Diane Sarkies - OBJECTIONS TO THE CHERRYBROOK STATION

Sharon Stanford, 4 Oliver Way, Cherrybrook
Submission to Application number SSI-5414

RE: Submission to Object application number (SSI-5414)

Figure 6.12 Cherrybrook Station - Indicative vehicle and pedestrian movements

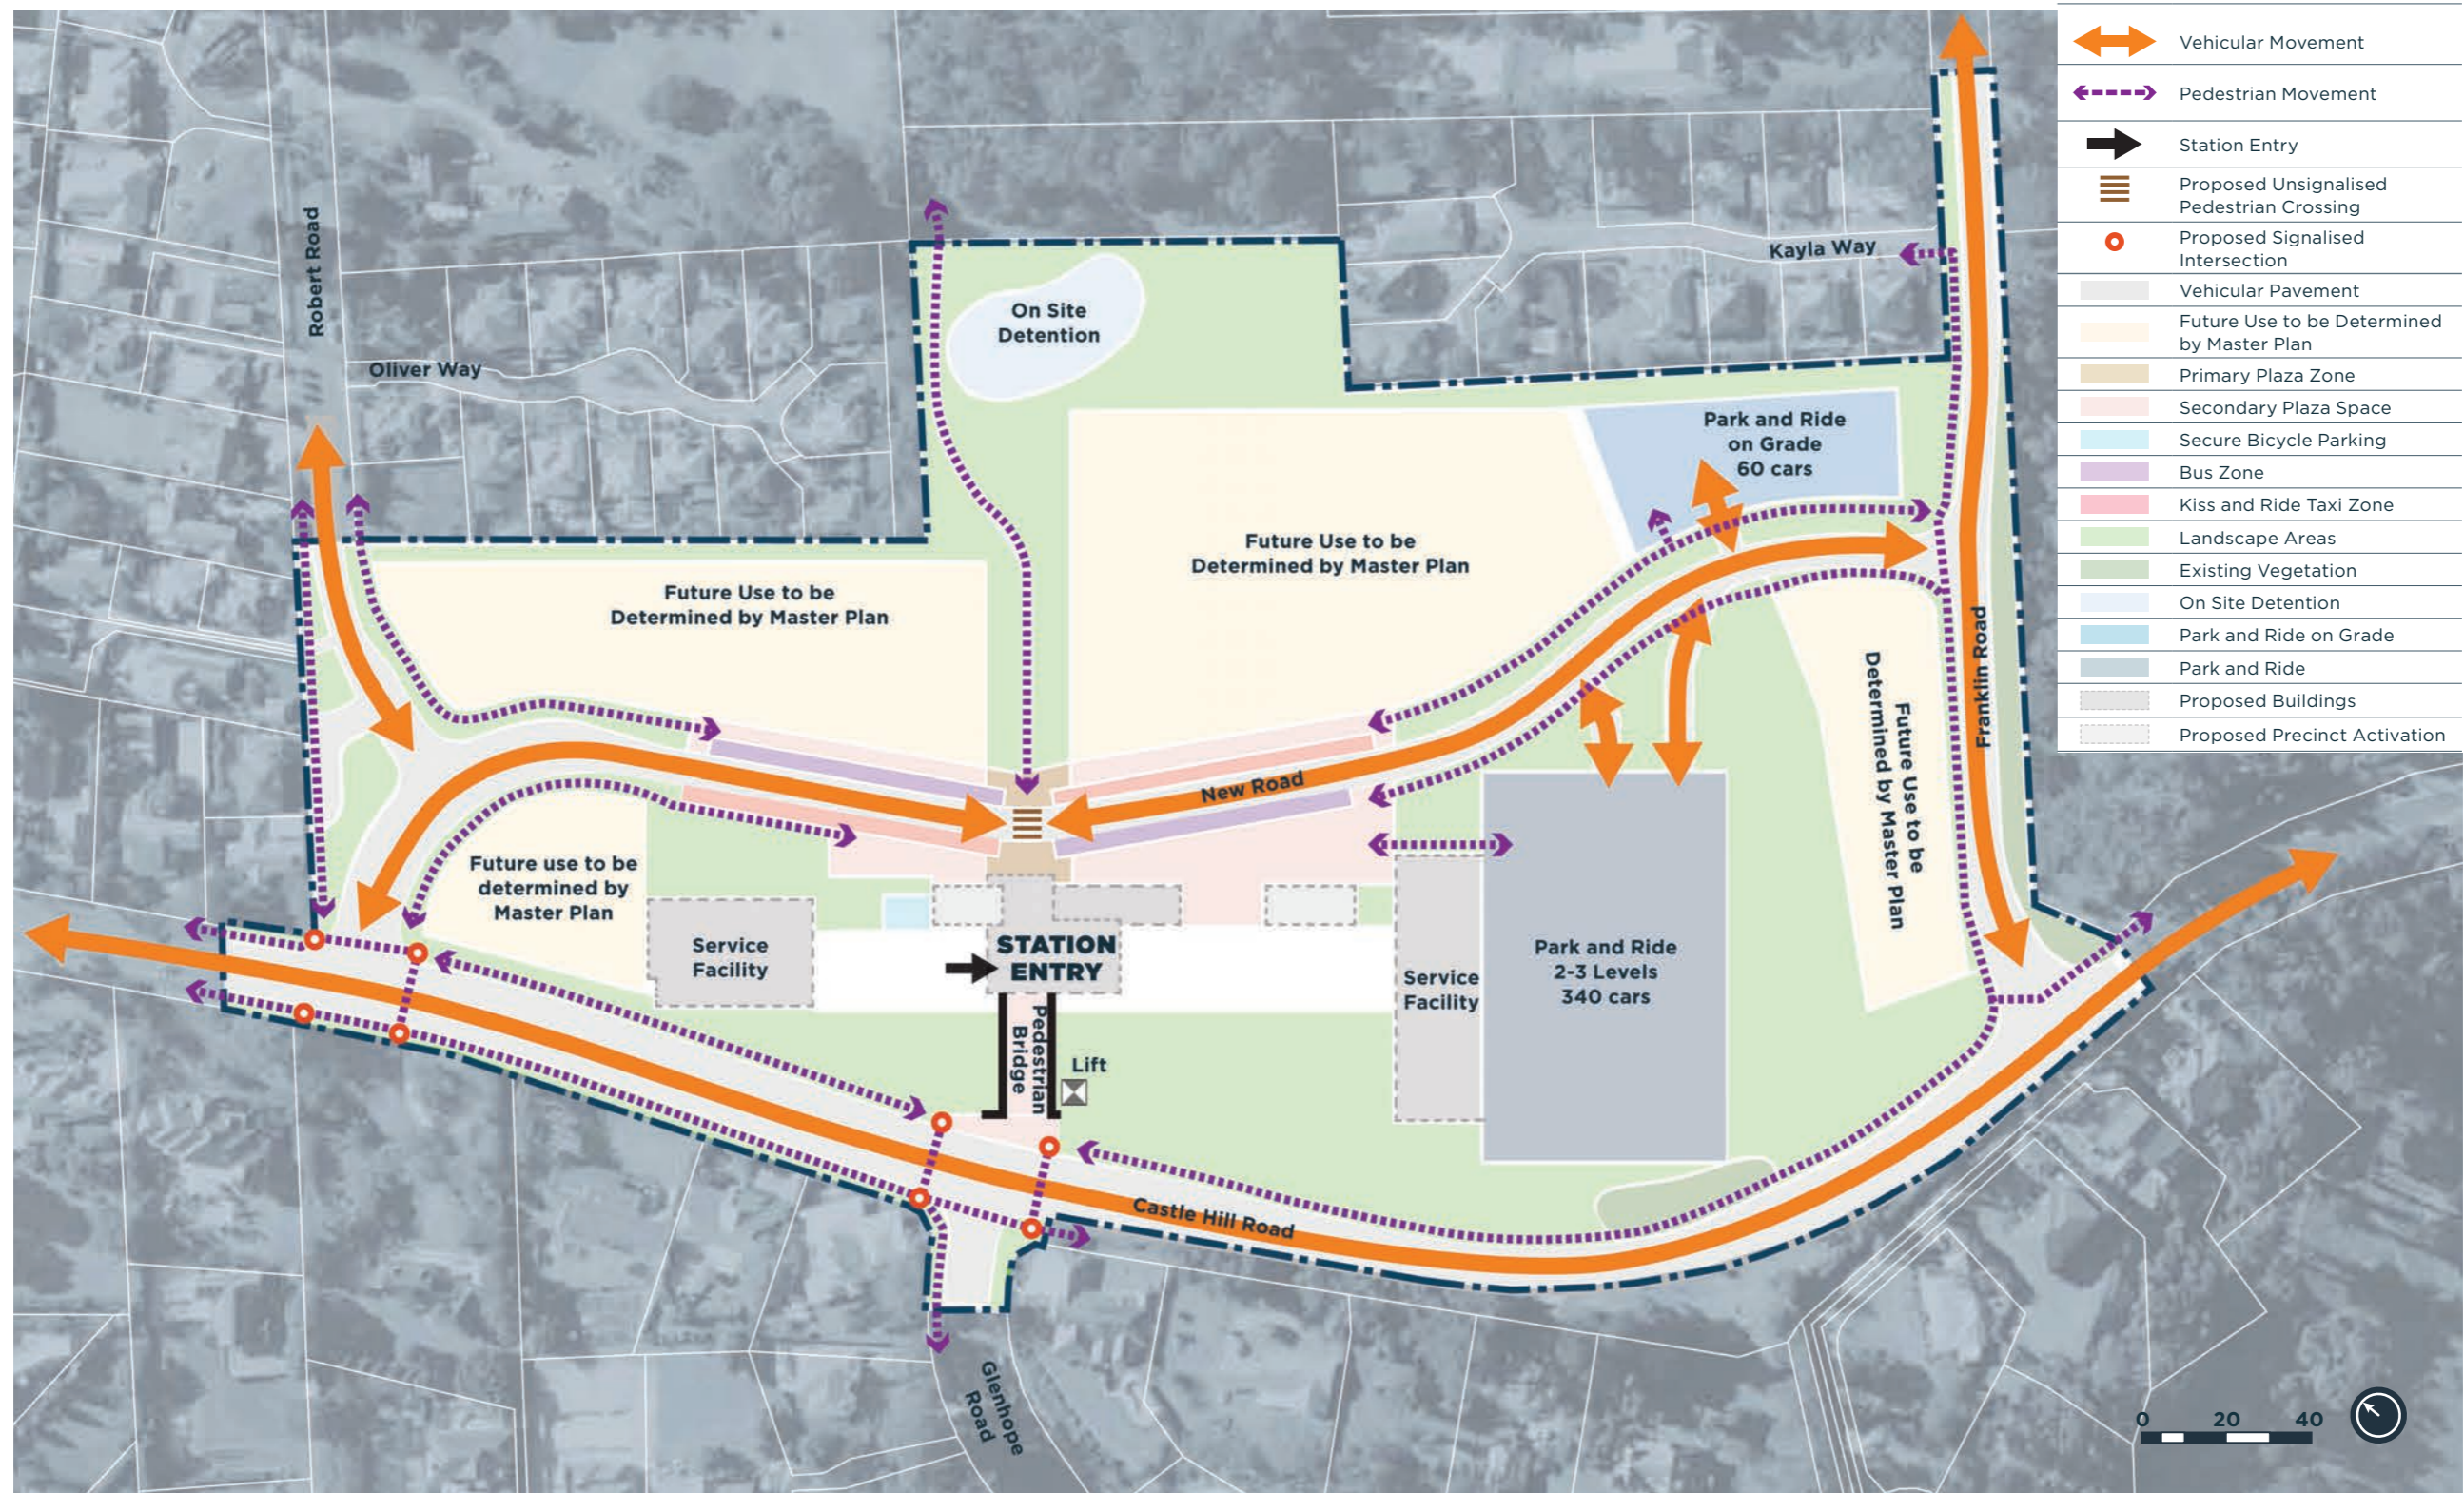
In relation to the NWRL proposal in EIS 2 of running buses south on County Drive, left into John Road and right into Robert Road, the NWRL is trying to capture commuters to and from the city who are currently situated at the bus stops on John Road between County Drive and Robert Road. I object to Robert road being used.

Oliver Way is a narrow road that relies on Robert road to gain entry and exit to our homes. Robert road is already under strain as people have to park there, in doing this it is very dangerous to see incoming traffic. I object to Robert Road being used and cannot see how this road will be used. Again we have little information on where and what this will be used for. I keep my boat on a piece of ground off Robert road and currently find the traffic congestion is terrible and often find myself parked in. Adding the station traffic will only cause further problems.

There was a suggestion by one of the representative of NWRL on the 19th of April 2012 to Robert Road as a feeder road into Cherrybrook station. This suggestion is seen by our group as a complete lack of knowledge as to the traffic movements in Robert road, (see below) and to accept Robert Road as a feeder road in any capacity would endanger to lives of residents of Oliver Way and

It is imperative that there should be no access into Robert Road from the Western end of the Cherrybrook Railway Station complex, and we further propose that Robert Road be converted into a cul-de-sac.
